# H2Teesside Project

Planning Inspectorate Reference: EN070009

Document Reference: 8.25.6 Response to ExQ2.6 Compulsory Acquisition and Temporary Possession

Date: December 2024

APPENDIX 1: MAP OF INDICIATIVE LOCATIONS EXCEEDING ORDER WIDTH

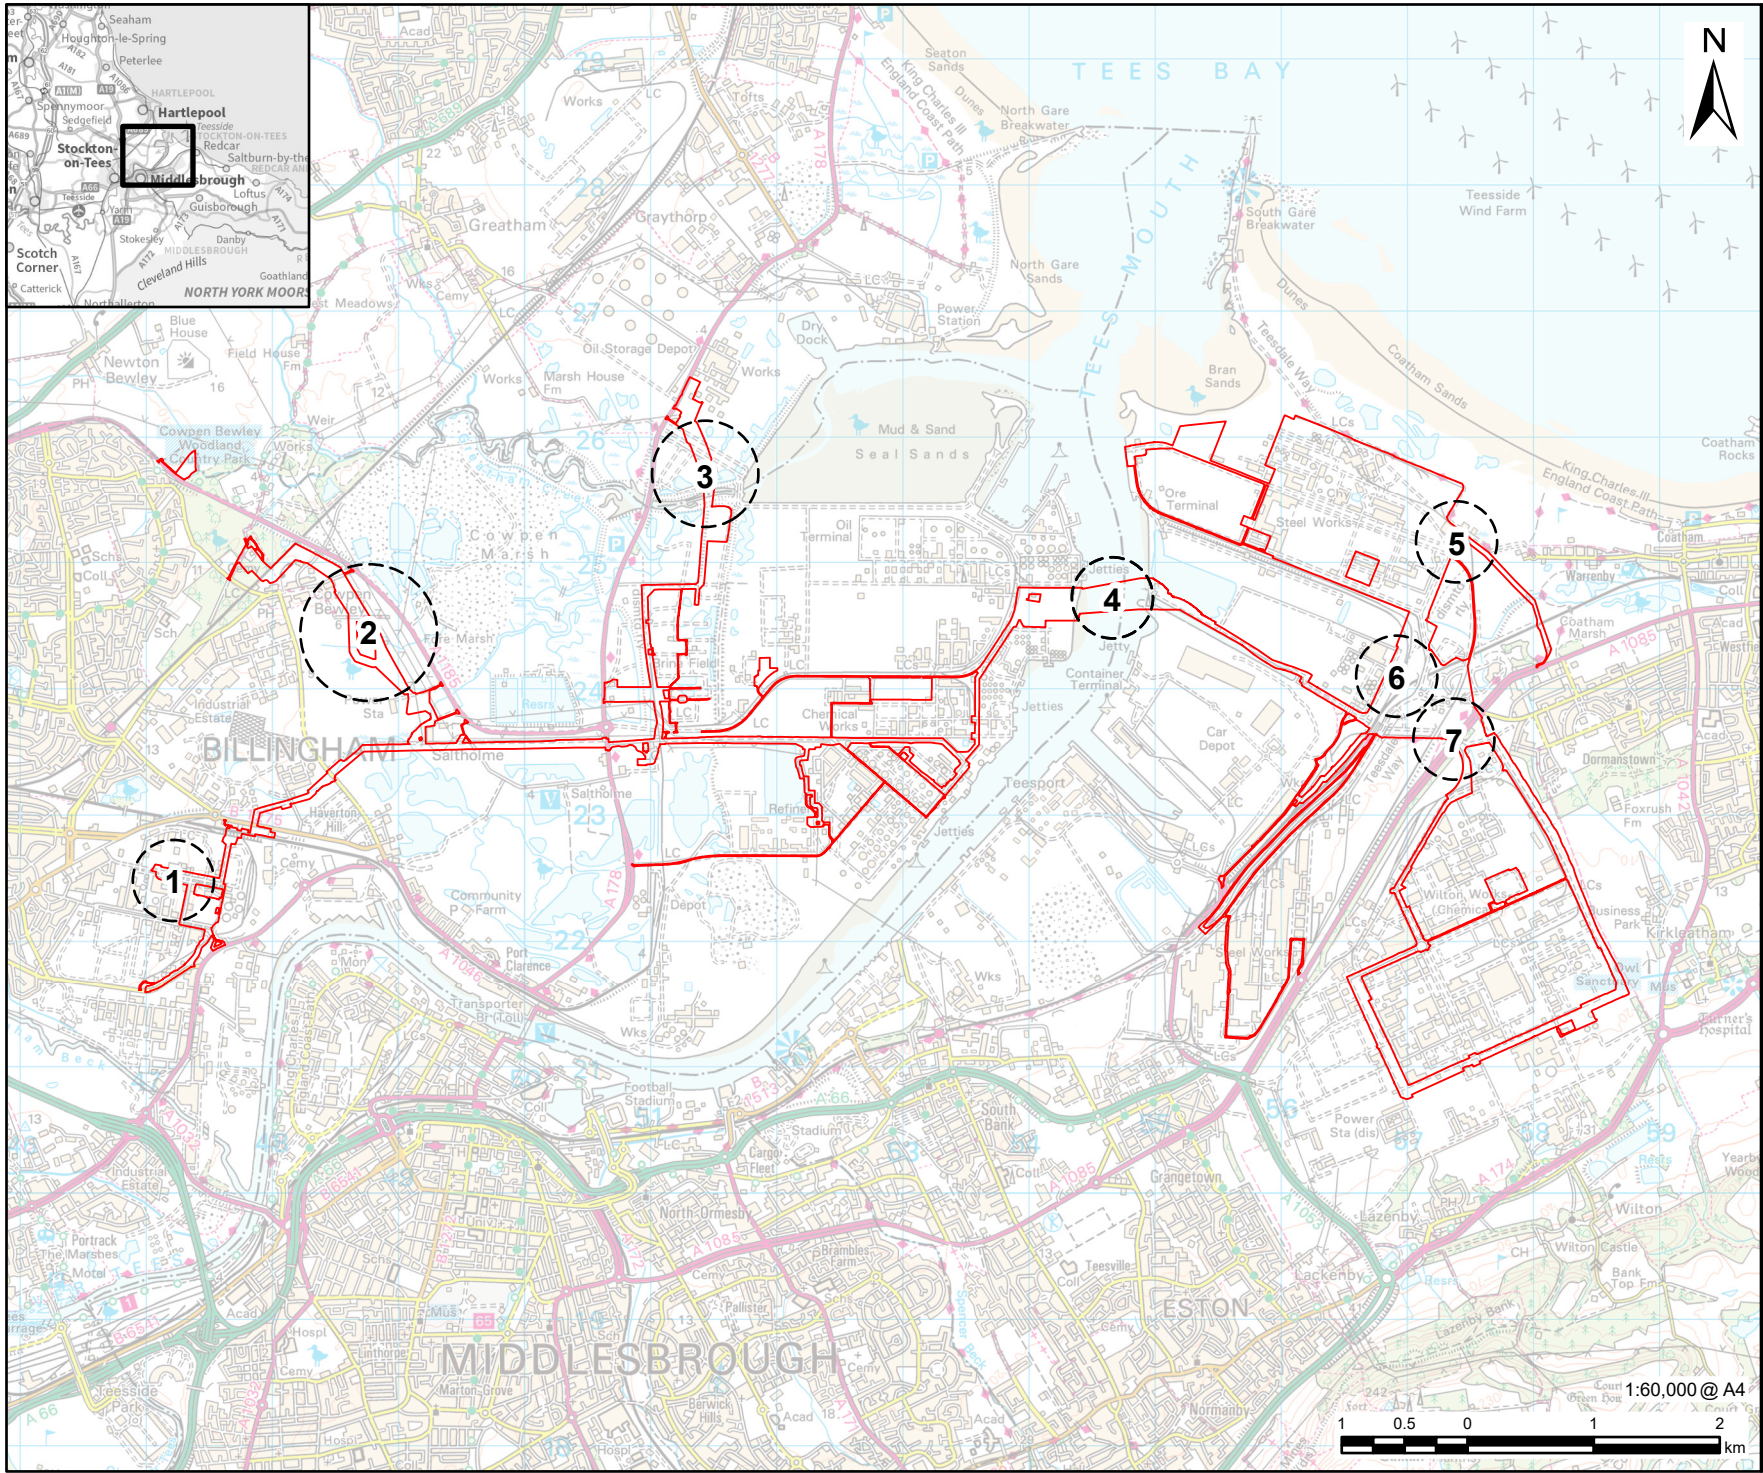
Q2.6.17	IPs and APs	At DL2, the Applicant provided a document Order Width Limit Explanatory Note [REP2-037]. Please provide any comments on this note if you have not done so at previous DLs.	N/A
Q2.6.18	Applicant	At DL2, the Applicant provided a document Order Width Limit Explanatory Note [REP2-037], at paragraph 3.2.3 it is stated that the results of the archaeological survey in the Cowpen Bewley corridor will be completed in Q4 of 2024. Please advise when this will be undertaken and if these results will lead to a resolution of the ‘coffee cup handle’ options before the close of the Examination.	The archaeological field evaluation of the Cowpen Bewley corridor was completed between the 18 <sup>th</sup> and 20 <sup>th</sup> of November 2024. An interim report was prepared by the archaeological contractor on the 3 <sup>rd</sup> December 2024 and is currently under discussion with the county archaeologist. The final report, along with any changes to the design will be provided prior to the close of Examination.

Q2.6.19	Applicant	At DL2, the Applicant provided a document Order Width Limit Explanatory Note [REP2-037], at paragraph 3.2.5 it is stated that the width of the corridor at the railway is 120m; similarly paragraph 3.3.2 details the corridor width at Greatham Creek as 125m. Please explain why this width has been chosen and if any particular technical, geographical or physical features, for example, have dictated this width. Please also advise if any further information which supports the need for this amount of land and why geotechnical investigations were not available prior to submission of the Application.	<p>The width of the railway crossing is set approximately as the width of the existing AGI to the north, which the new AGI will be adjacent to and is the eventual tie-in point for the pipeline. The new AGI can be in the centre, to the west or east, and taking the whole width allows flexibility of the crossing towards that location.</p> <p>Greatham Creek has a curved path based on the entry and exit locations of the HDD. 125m is the approximate width of this curved path, and this has been determined due to the following factors. The south side (HDD exit) is more certain as pipe stringing will be parallel to the existing track. The north side (HDD Entry) is less certain due to a lack of project specific geotechnical investigation and the existing pipeline corridor. There is a pond on the north side, north of the pipeline corridor and south of the facility, outside the redline boundary, which had a buffer of 20m applied when drawing the RLB.</p>

EXQ2	QUESTION TO:	QUESTION:	RESPONSE
			Geotechnical information was not available as it is currently scheduled to be performed next year. A desktop report was produced using existing BGS boreholes (and others known/available) in the previous phase, ahead of DCO submission. The desktop report and existing boreholes were used to select HDD as the preferred crossing technology/method.
Q2.6.20	Applicant	In ExQ1 Q1.6.30 [PD-008], the ExA sought information about Government funding for the Proposed Development. Please update the ExA on any further developments or changes in this regard.	<p>The position previously outlined in the Applicant response to ExQ1 Q1.6.30 [PD-008] remains valid.</p> <p>Since the submission, H2Teesside's negotiations with the Government to secure the required funding through the Low Carbon Hydrogen Agreement (LCHA) and Net Zero Hydrogen Fund (NZHF) have progressed well. As set out in our previous response, a Statement of Principles was agreed in summer 2024, which allowed the project to progress to final negotiations.</p> <p>The Applicant remains confident that the necessary Government support will be provided and that this will help to ensure the project's successful implementation and contribution to the UK's net zero targets.</p>
